05/06/2020

**Moorebank Intermodal Precinct West - Stage 3 (SSD-10431)
Response to Submissions**

Attachment 1: Supplementary Key Issues

STAGED PLAN OF PROPOSED SUBDIVISION OF LOT 1 DP1197707 AND LOT 100 DP1049508

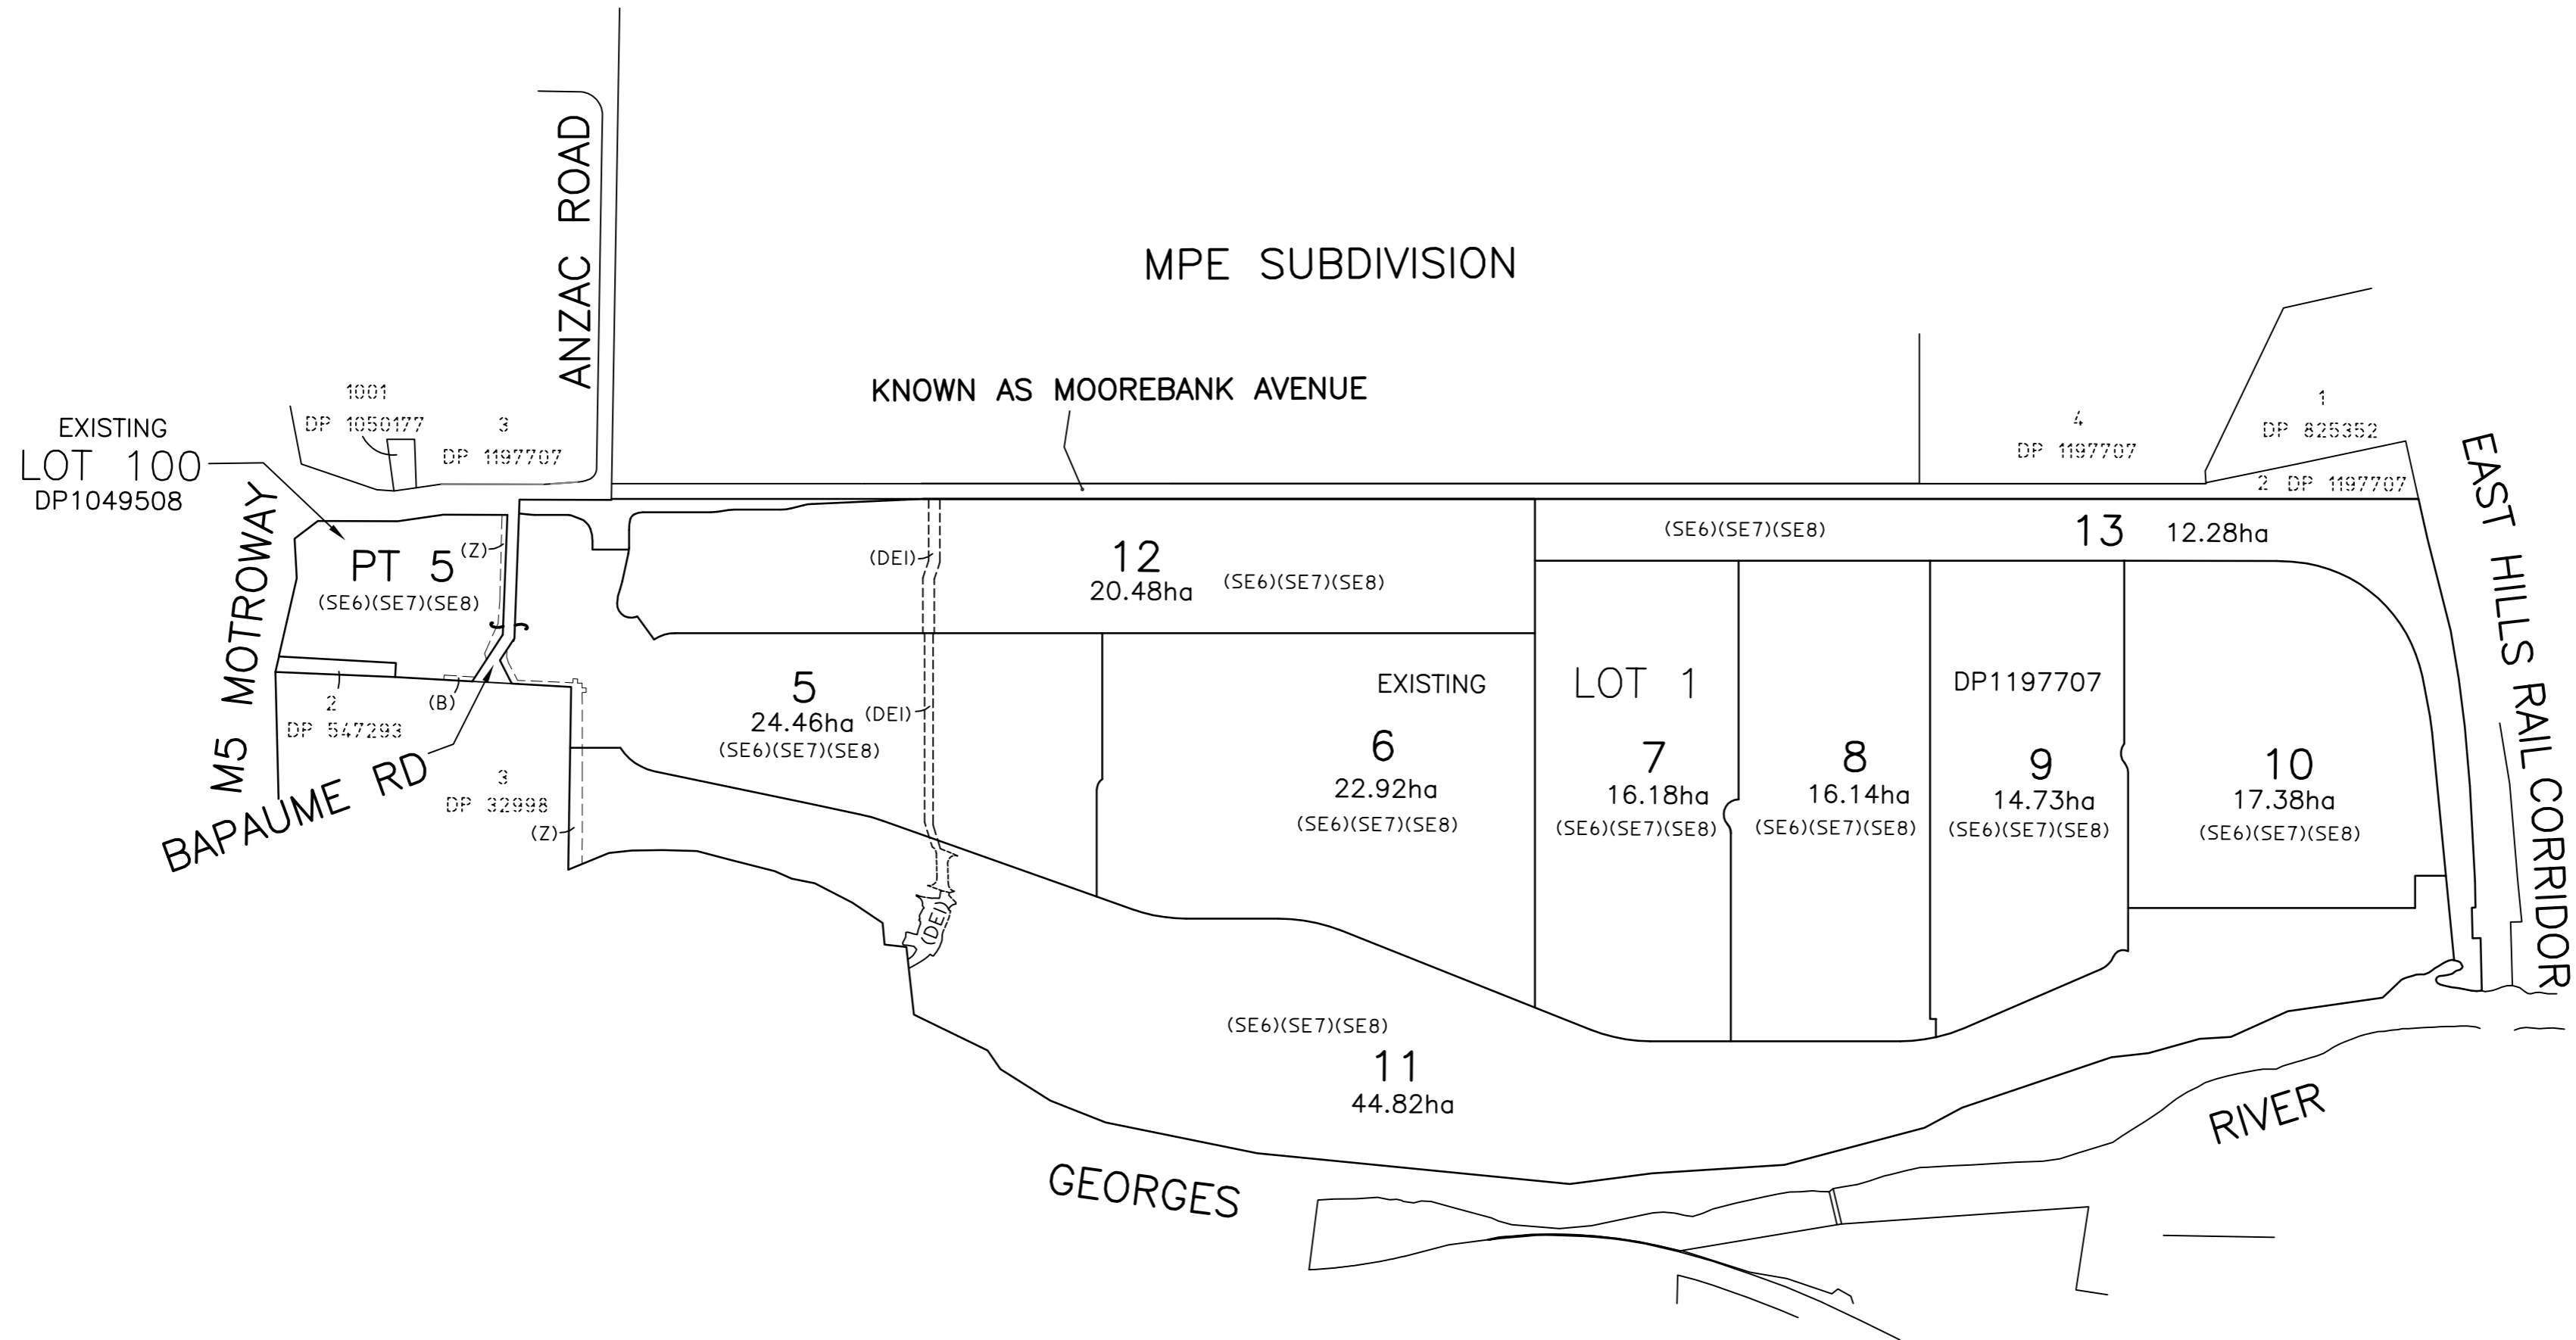
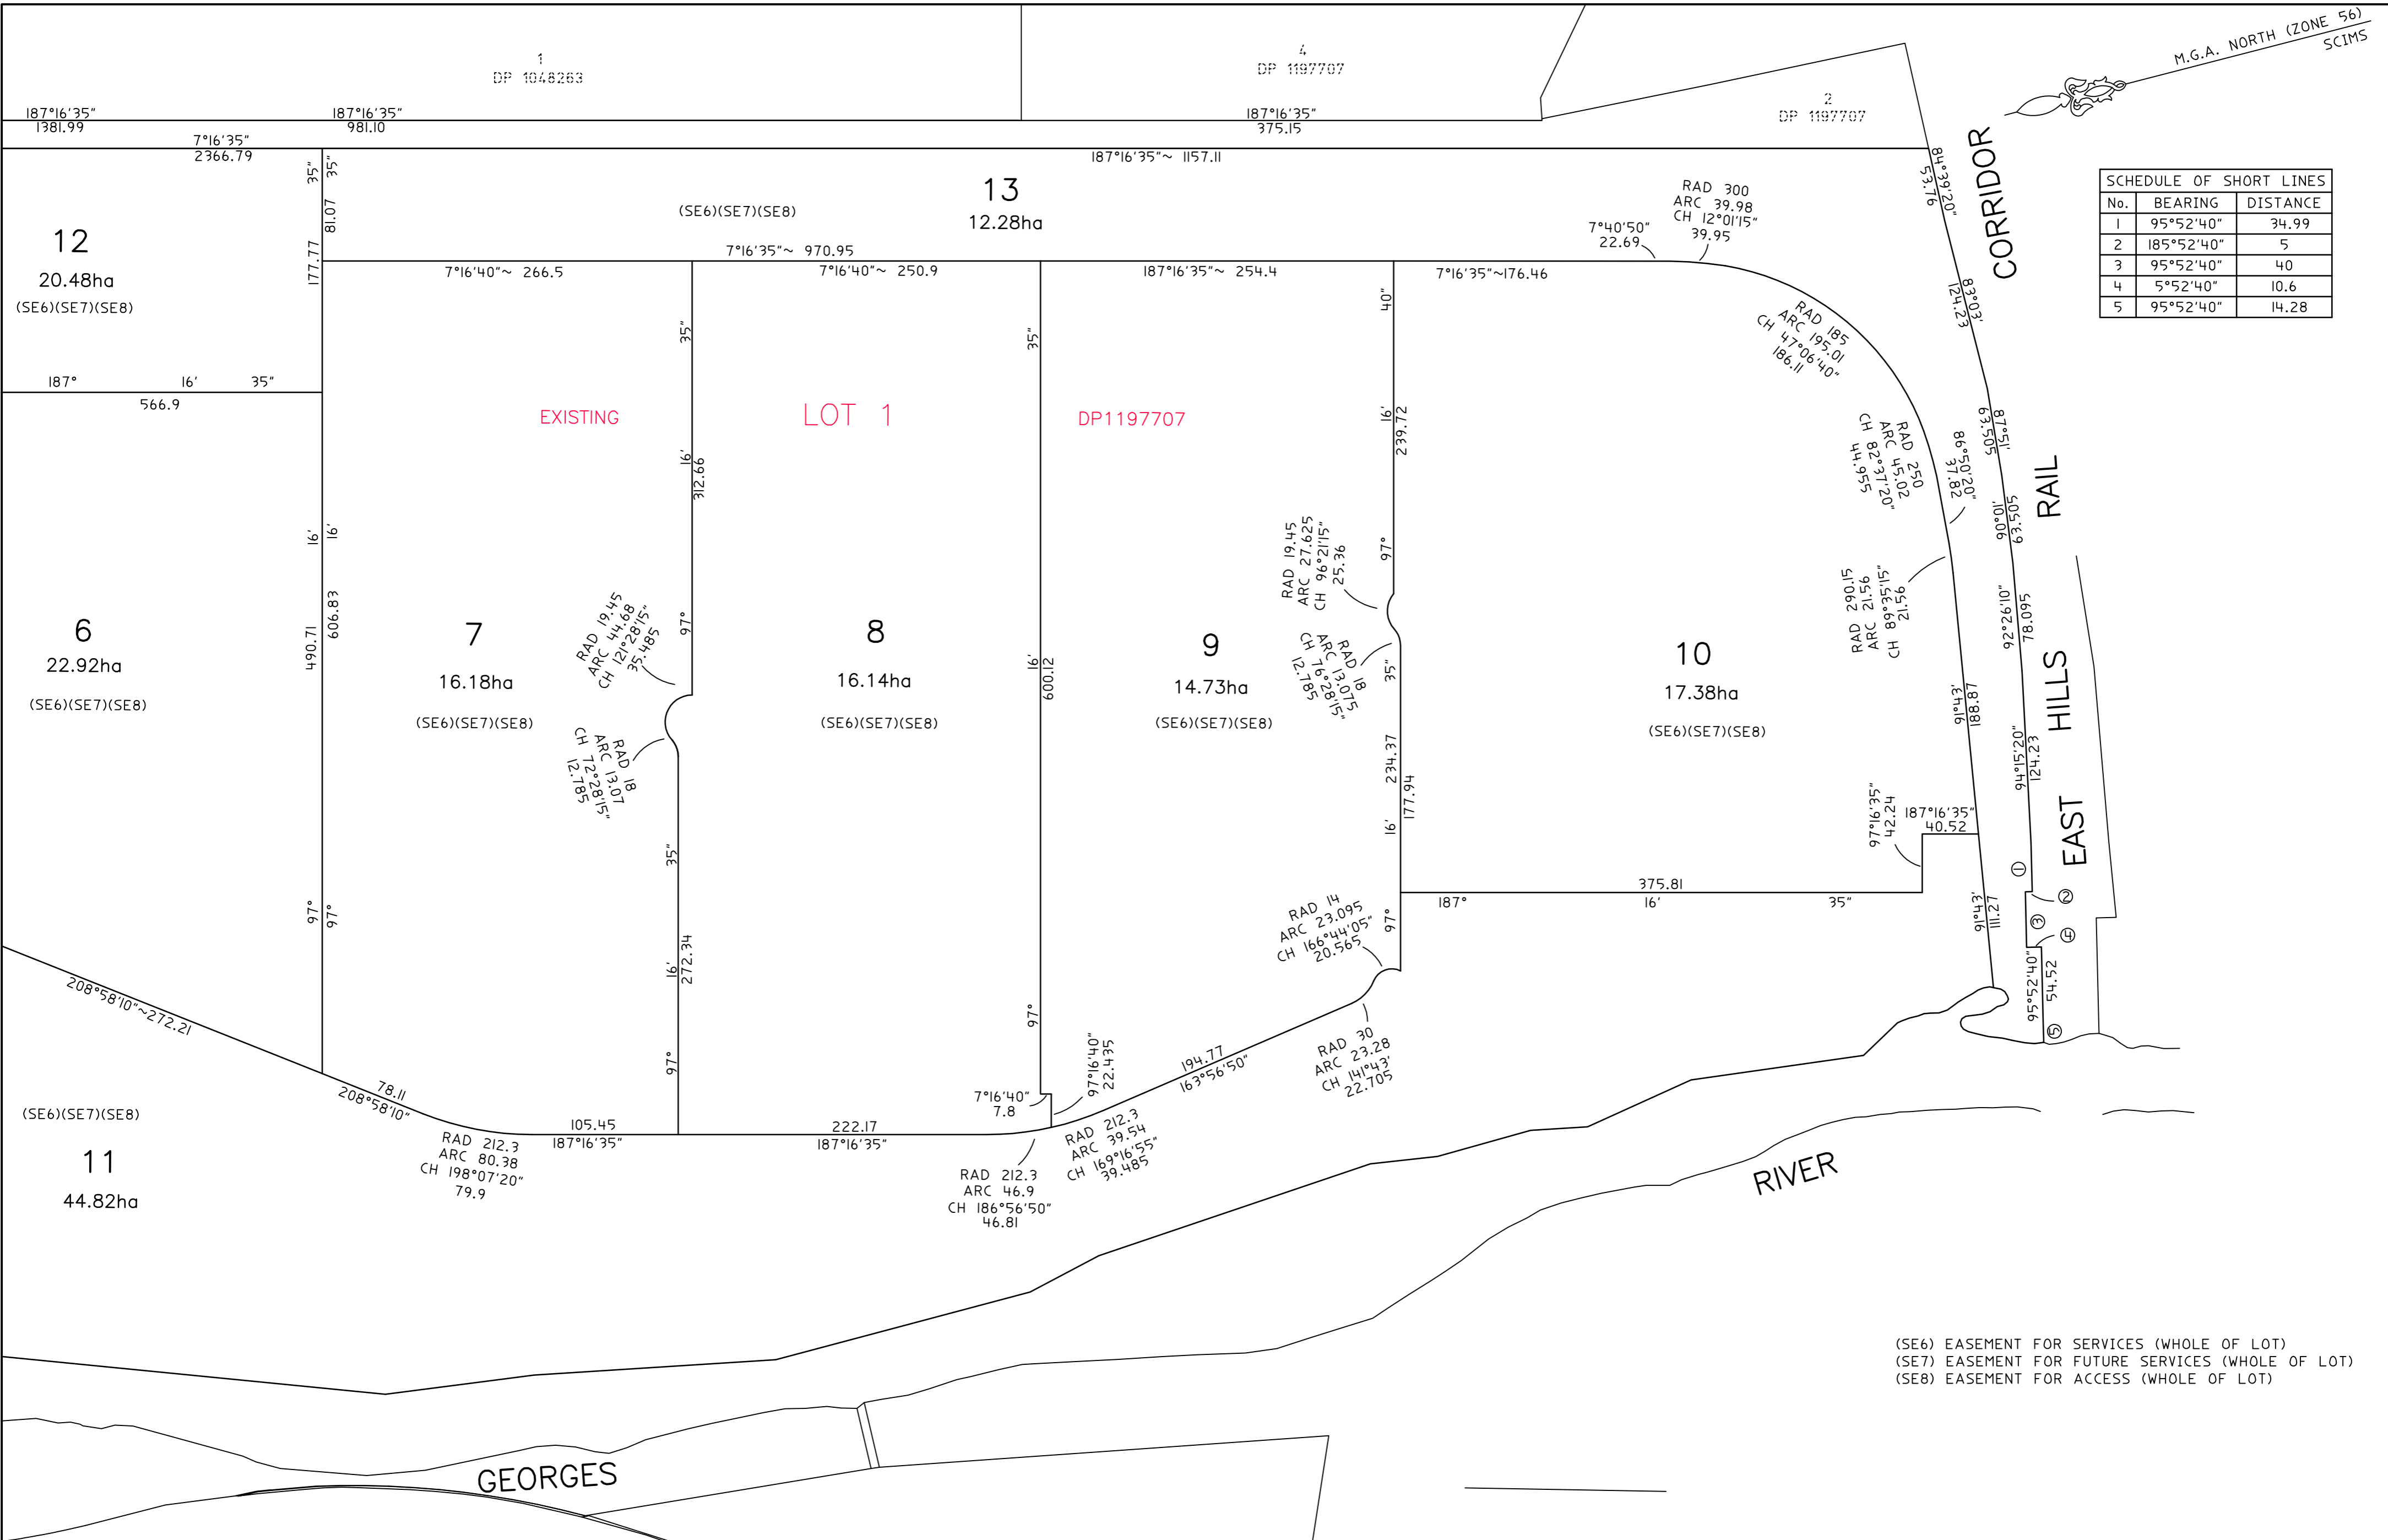
Further information is required to support the Applicant's 'Clause 4.6 Request – Minimum Lot Size Requirements' (Appendix F of the EIS) and subdivision plans provided as part of the EIS.

In particular, the Submissions Report must provide a detailed response demonstrating how objective (c) in clause 4.1 (1) of the LLEP would be achieved, including the mechanisms proposed to prevent fragmentation of the MPW site. This includes demonstrating how the construction, operation and management of the MPW site would allow for the development of a 'holistic intermodal freight terminal', rather than an industrial park or estate.

The Department requests that further information is provided to demonstrate compliance with the requirements of condition E26 of Schedule 4 (Conditions to be met in future development applications) of SSD 5066 (as modified). In particular, the Submissions Report must address the requirements of condition E26 (c) in detail and provide an updated set of subdivision plans that clearly illustrate completed estate works for the entire MPW site, including maintenance of access roads, pedestrian paths, landscaping, lighting of common area and provision for emergency services including for firefighting. If this information has been submitted to the Department as part of an Urban Development Design Report (UDDR) for MPW Stage 2 works (northern portion of the MPW site), then that information must also be provided as part of the Response to Submissions Report. This information is also required for the proposed works compound in the southern portion of the MPW site.
